Solar park including the erection of solar arrays, inverters, transformers, equipment housing, security fencing, internal tracks, ancillary equipment & ecological mitigation. This application is a Departure from the Development Plan.

Land at Barnhan Court Barnham

Thank you for your internet representation made on 27th August 2015 which has been recorded as '**an objection**' with the comments as follows:

Figure 2 - Routing Strategy

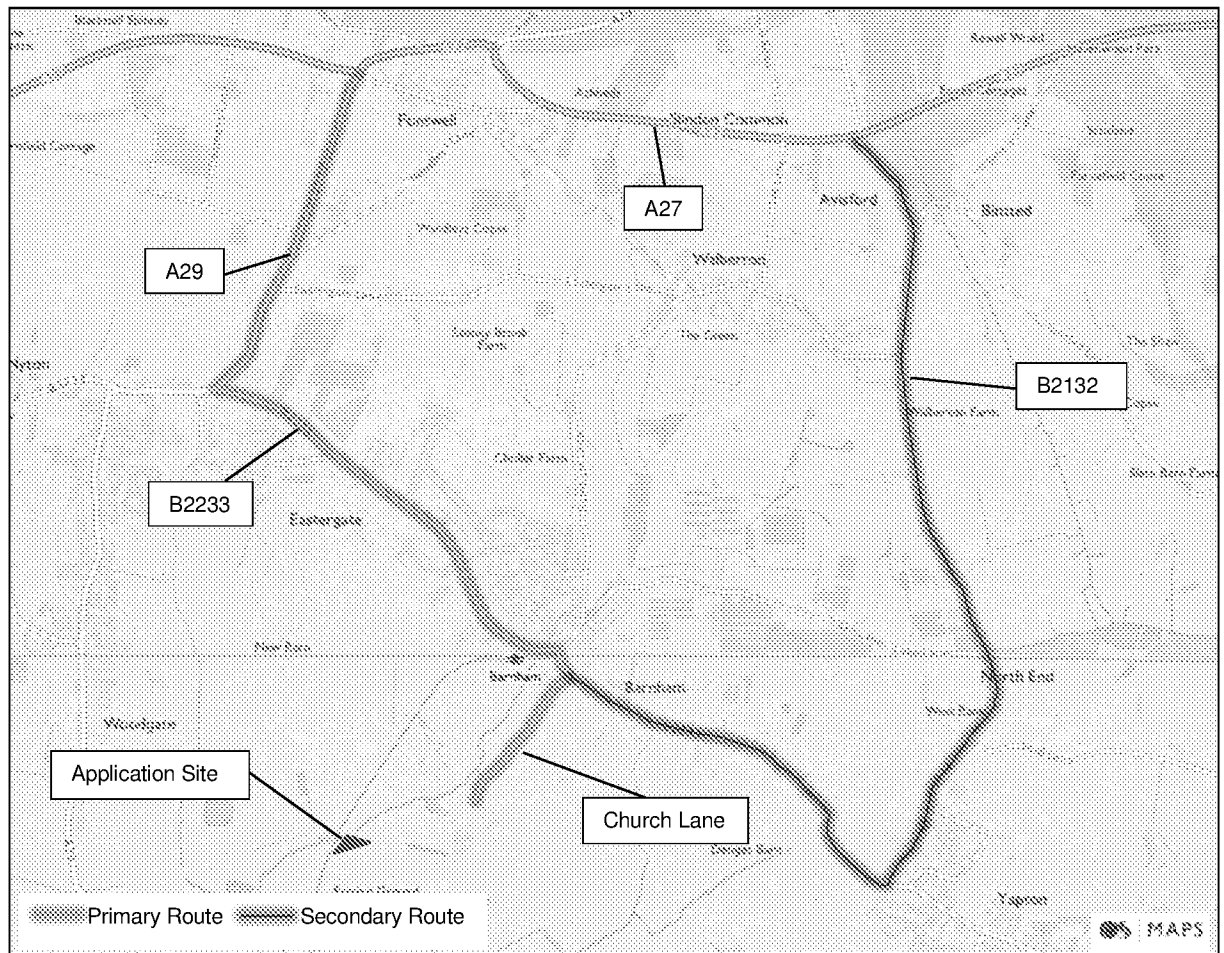
Objection to use of Church Lane for construction traffic as it is mostly single carriageway and is heavily used by pedestrians and cyclists, with no pavement, or even verge for much of its length. There are several blind binds, the one by St Marys Church being potentially very dangerous for cyclists and pedestrians. It is part of the Barnham to Felpham cycle way.
